From: Charlotte Easton
Sent: 29 January 2019 11:01
To: 'Max Thoms'
Subject: RE: 19 Priory Road, Arundel - AB/129/18/HH

I write to you regarding the application submitted at 19 Priory Road, Arundel – AB/129/18/HH.

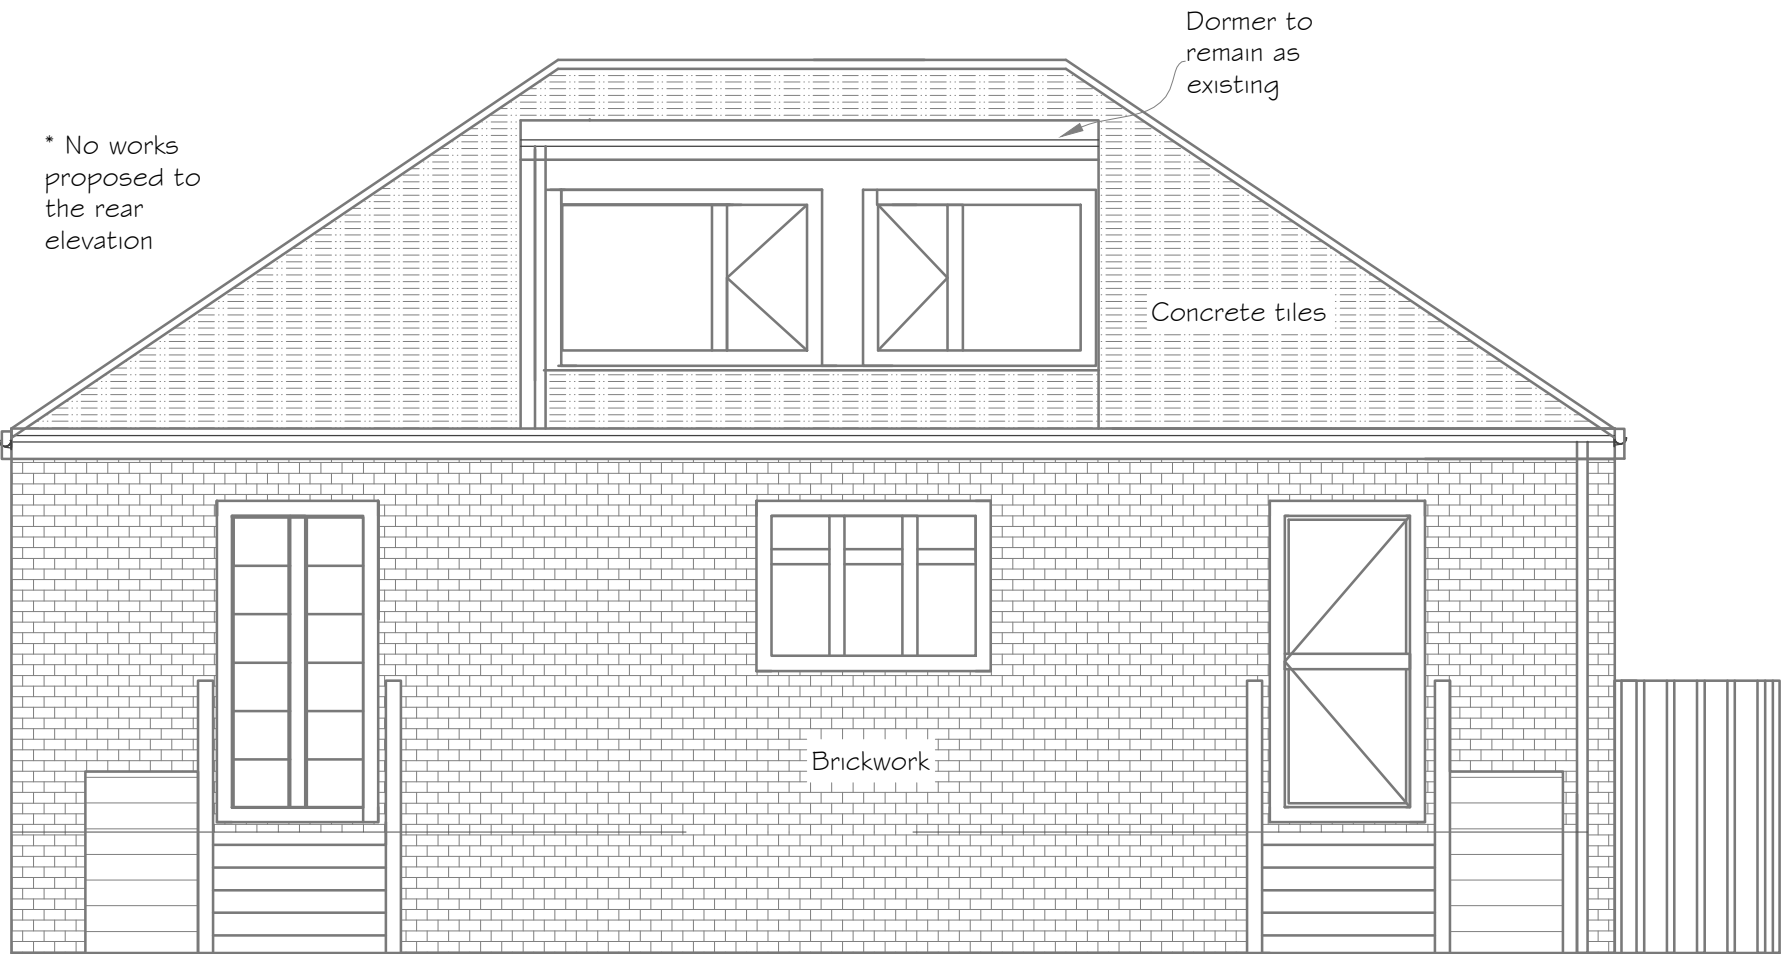
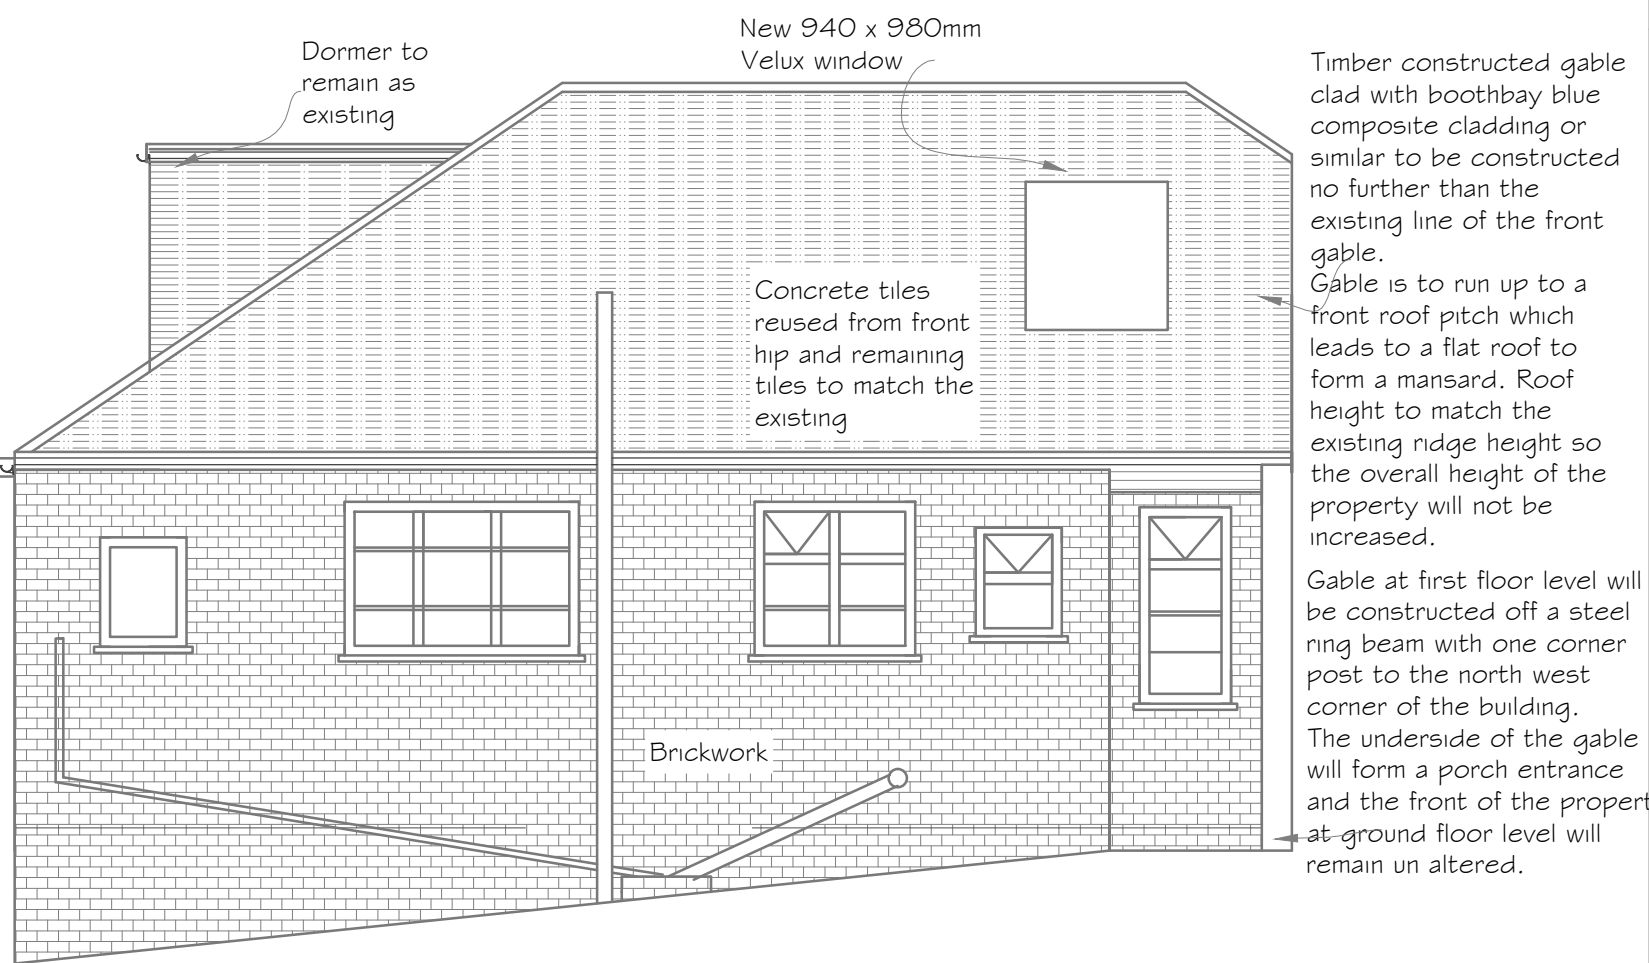
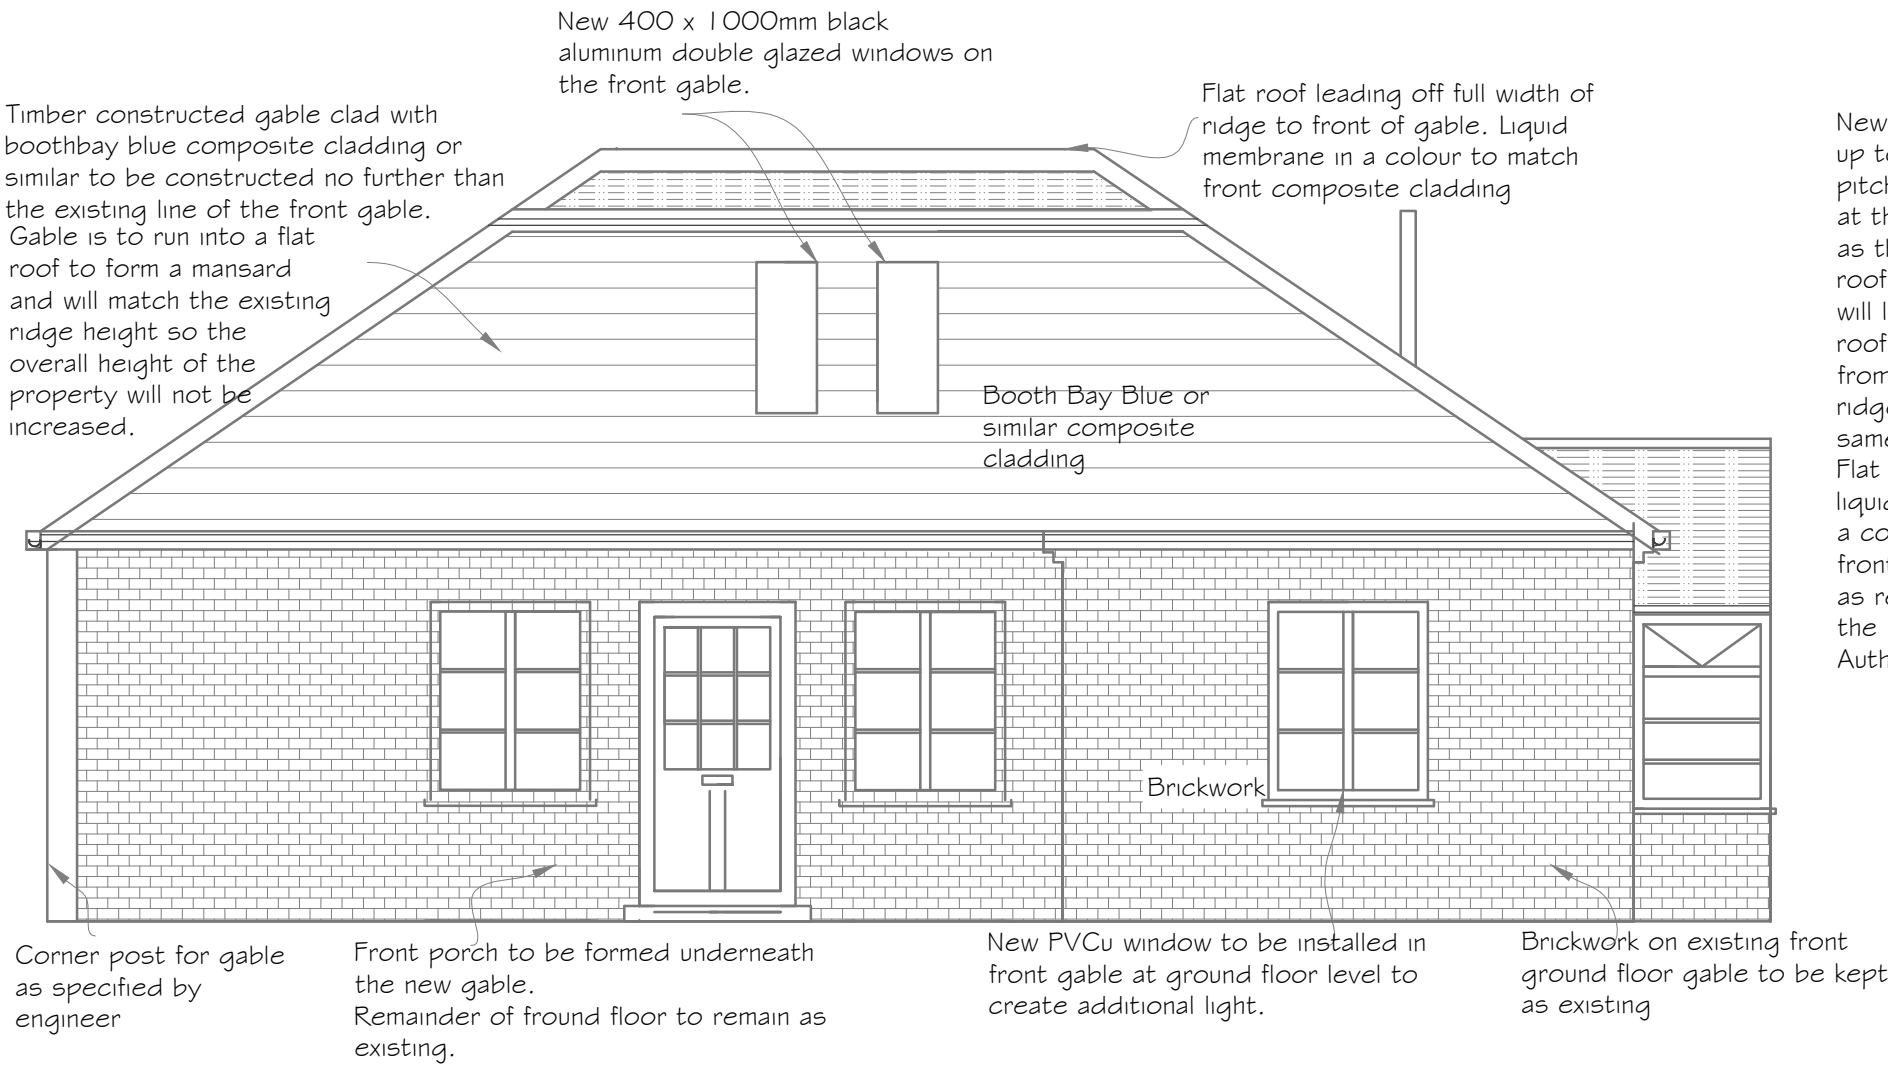
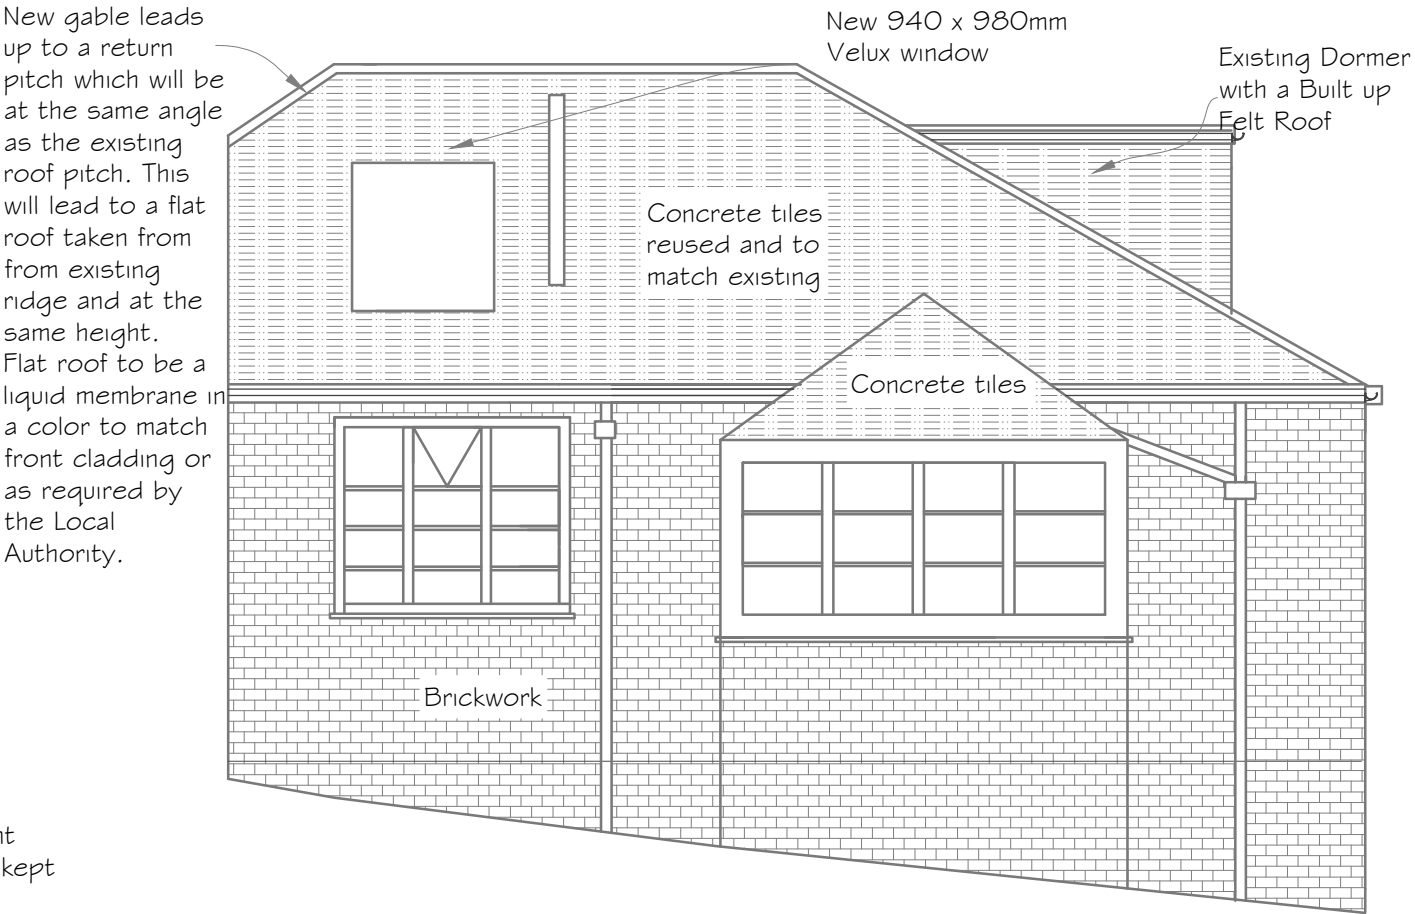
I need to clarify with you if the cladding materials proposed are confirmed as Booth Bay Blue, as the plans state 'Booth Bay Blue or similar'.

We will condition the application to accord with the submitted plans and the condition will state Booth Bay Blue.

Thanks for the email. I was proposing a Booth Bay Blue but am happy with an alternative if needs be.
